CITY OF MERCER ISLAND

July 30, 2018

Re: Review Letter for CAO18-003 - Critical areas Determination
Regarding: possible piped watercourse and the type IV wetland located at 8114 West Mercer Way Mercer Island, WA 98040; Parcel ID: 33585-00974

Figure 4. Site Plan Showing Proposed Buffer Reduction and Addition Areas

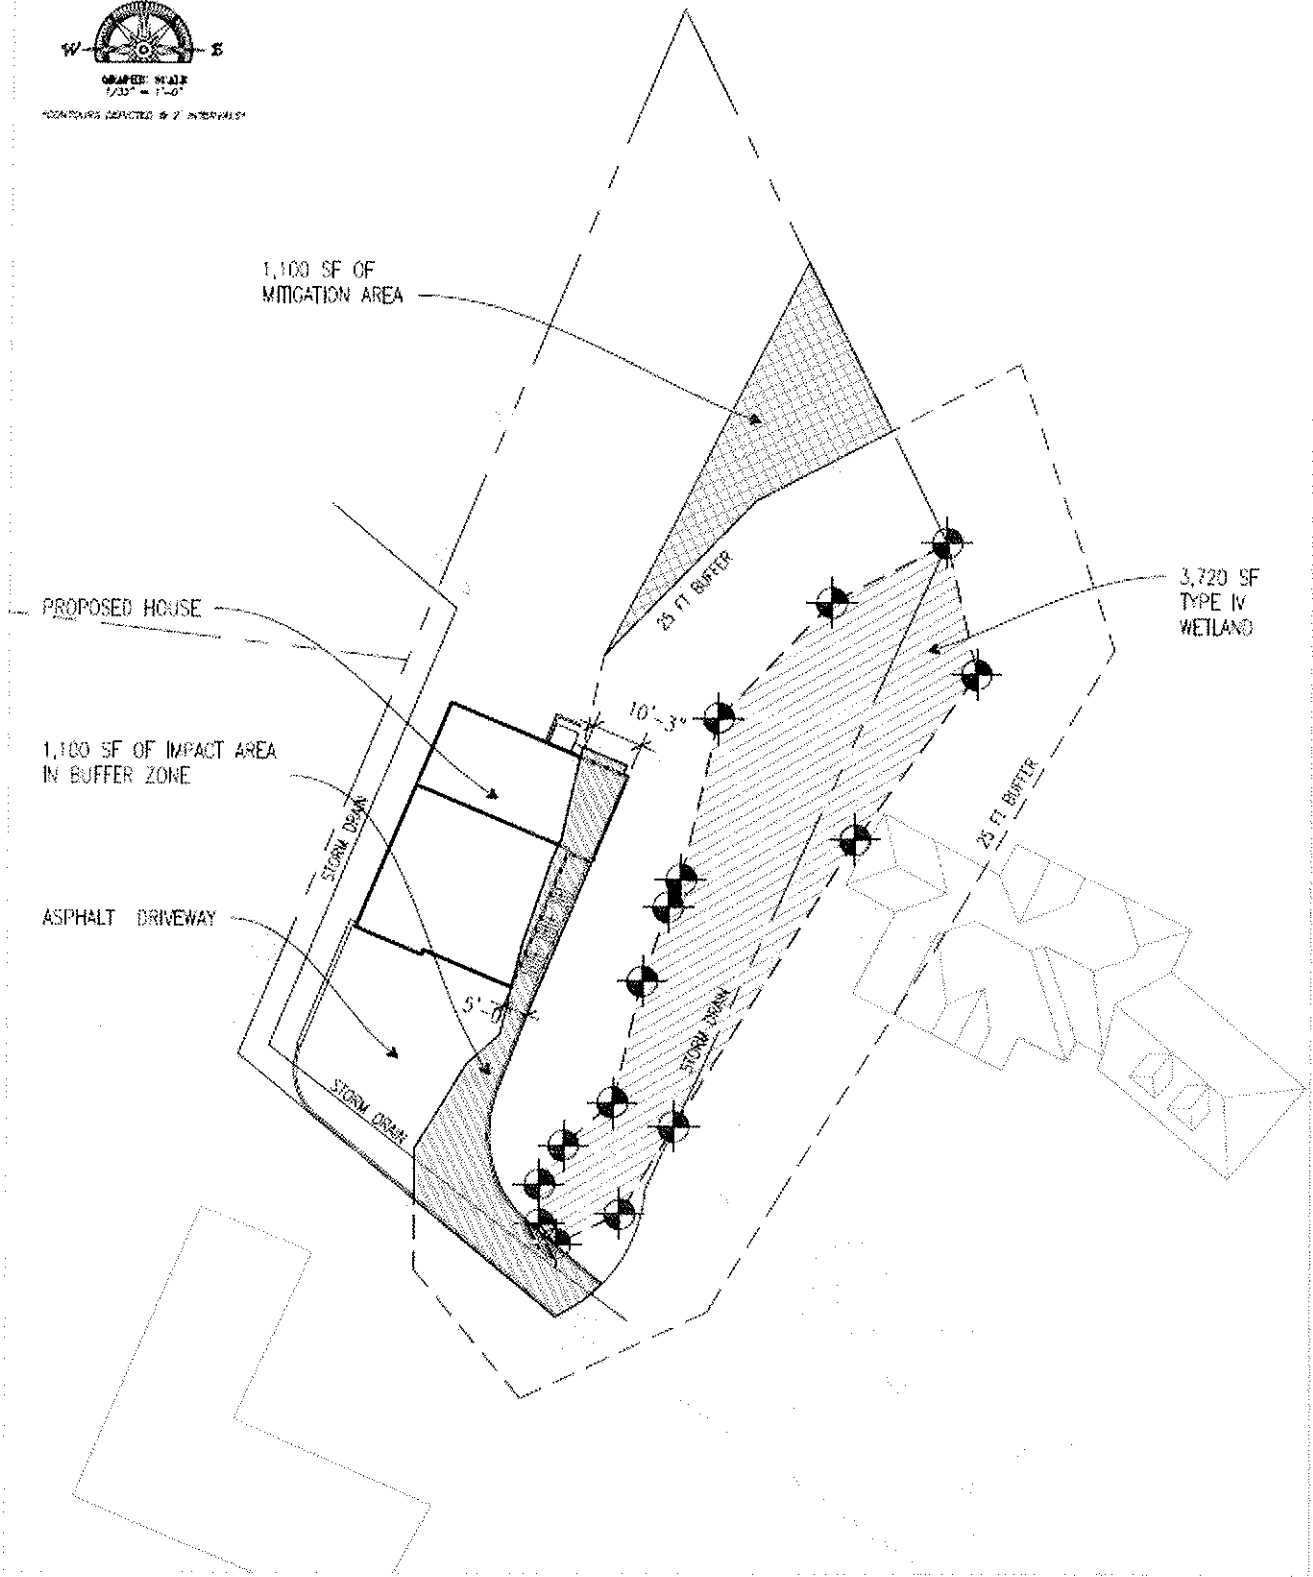
4. Site Plan. Please revise the site plan to include the following items:
- a. Indicate the original (35 foot) and reduced (25 foot) Type IV wetland buffer.

- b. Indicate the location and classification of the 200 sf wetland and associated buffer.
 - c. Please remove the reduced buffer off-site, as this application is for 8114 West Mercer Way only.

- d. Please only show the reduced buffer for the house and driveway. No development is proposed in the upland area and consequently there is no need for a buffer reduction.

- e. Indicate the extent of the steep slope on-site, as the wetland buffer cannot be reduced in a steep slope. This can be illustrated with hatching on the site plan, based on the underlying topographic survey. MICC 19.16 defines steep slope as the following: *“any slope of 40 percent or greater calculated by measuring the vertical rise over any 30-foot horizontal run. Steep slopes do not include artificially created cut slopes or rockeries.”*

- f. Indicate the easements on-site and provide the recording numbers.
 - g. Clearly label the property line and dimensions.
5. Critical Areas Study.
- a. In the Critical Areas Study please clearly state how the new driveway complies with MICC 19.07.030(6):

9. Please state why the driveway, stairs, and northeast portion of the house was placed within the reduced buffer.

Can the above items be located outside of the reduced buffer to reduce impacts? There will be temporary construction impacts from excavation and installation of the house, stairs, and driveway that will encroach further into the reduced buffer. A 4-5-foot setback from the buffer should be provided to mitigate construction impacts and for long-term maintenance. Long-term maintenance includes maintenance of the house long-term such as painting and accessing the backyard.

Figure 5. Planting Areas to Provide Buffer Restoration and Enhancement

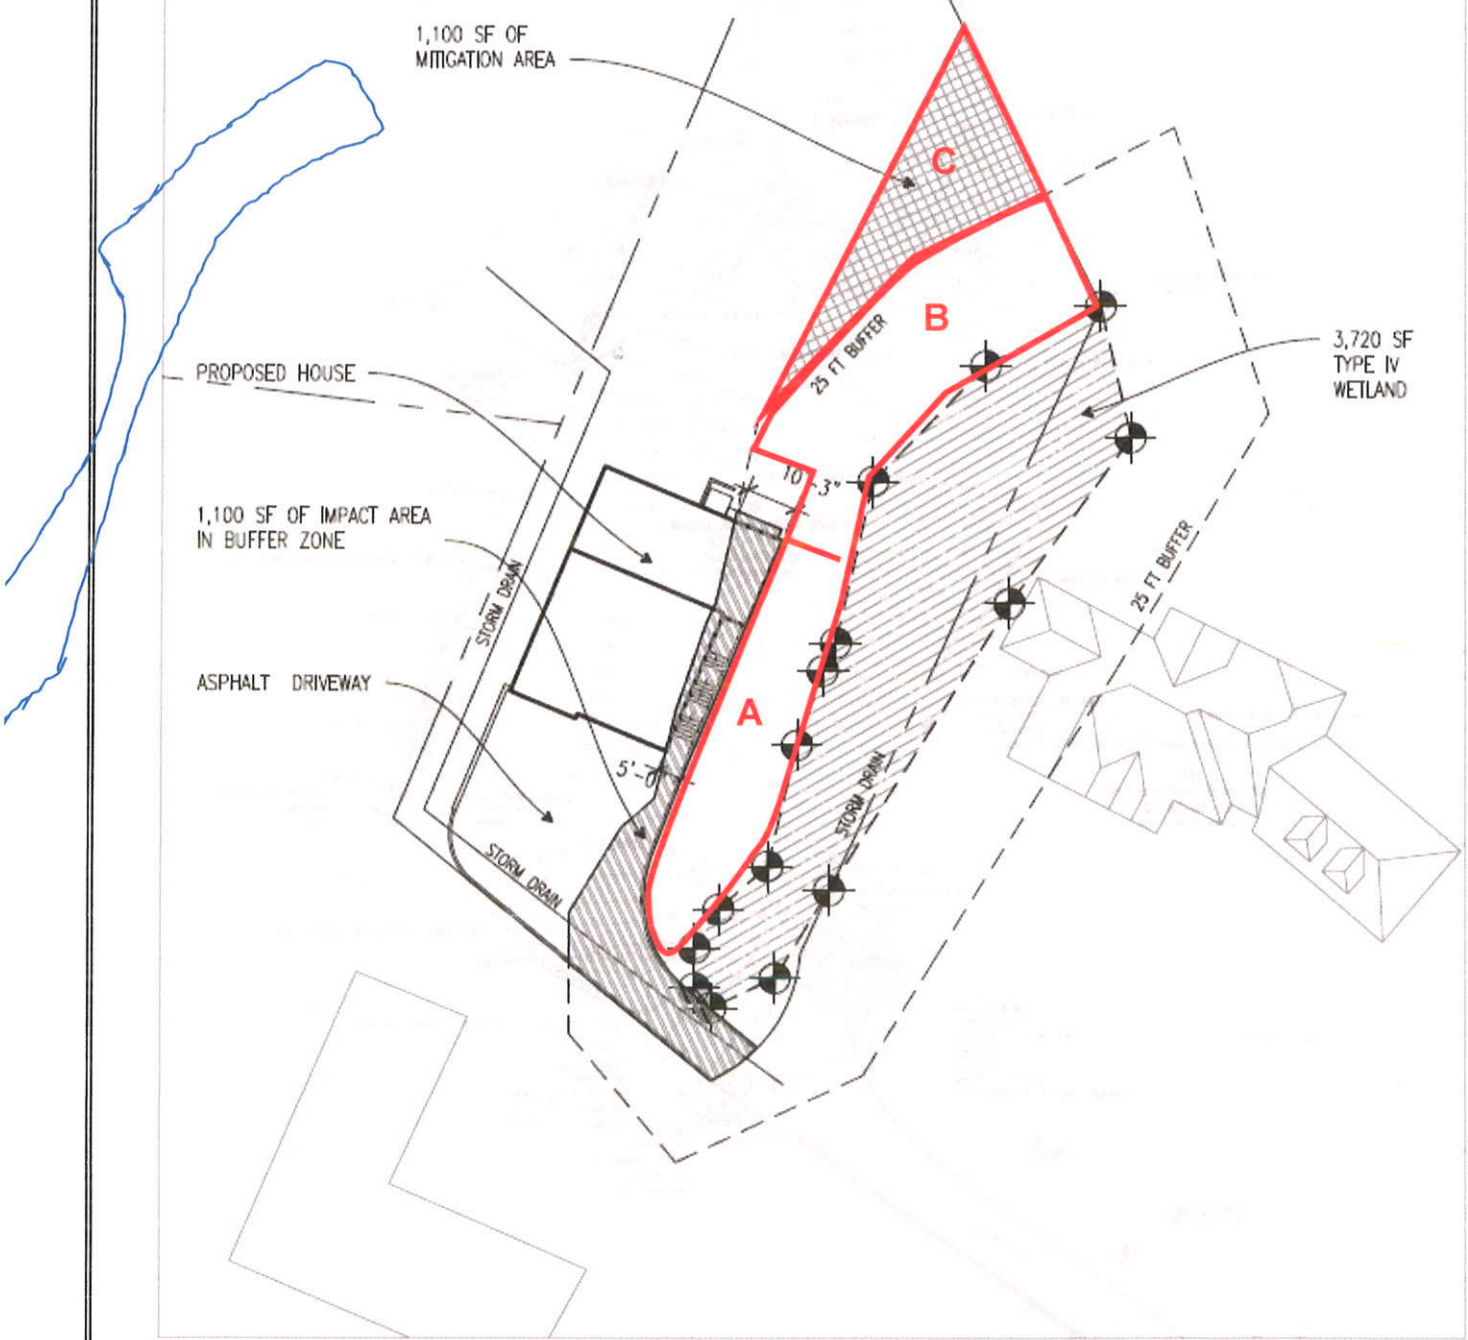
- b. Reconfigure the driveway or plant trees and/or shrubs along the edge of the driveway to protect the wetland to the extent possible.
 - c. Minimize impacts to the wetland and buffer by designing the house and driveway to be outside of the reduced wetland buffer.
3. Public comment. The City received multiple public comments, please refer to Attachment B. Please consider and prepare a response to the categories of comments:
- a. Landslide hazard: concerns about development with the steep slope and potential landslide hazard.
 - b. Water on-site: concerns about erosion and run-off and the potential impacts to neighboring sites.
 - c. Provided Documents: proposed plans and potential impacts (off-site) were vague, and a possible wetland was not indicated.

- According to MICC 19.07.030.6, new driveways are an allowed use within wetland buffers if mitigation occurs to the greatest extent practicable to ensure a no net loss in ecological functions. We agree that the proposed buffer mitigation is sufficient to offset the allowed buffer impacts caused by the driveway. However, the proposed driveway is currently located immediately adjacent to the southern end of Wetland A. Daily use of pollution generating surfaces, such as driveways, in close proximity to a wetland could result in a loss of the wetland’s water quality and habitat functions. We recommend the driveway be reconfigured to minimize impacts to the wetland. If not practical to reconfigure the driveway, we recommend that trees and/or shrubs be planted along the northern edge of the driveway to protect the wetland to the extent possible.

loss of function. In addition to the proposed buffer addition and buffer enhancement, we recommend wetland enhancement in the southern portion of the wetland where reed canarygrass is dominant. The hand removal of invasive vegetation (i.e. Himalayan blackberry and reed canarygrass) and the subsequent installation of native plants within this area would offset the impacts to the reduced buffer as well as reduce the impacts of the proposed driveway. We recommend the Wetland Mitigation and Monitoring Plan be revised to include wetland enhancement in the southern portion of Wetland A.
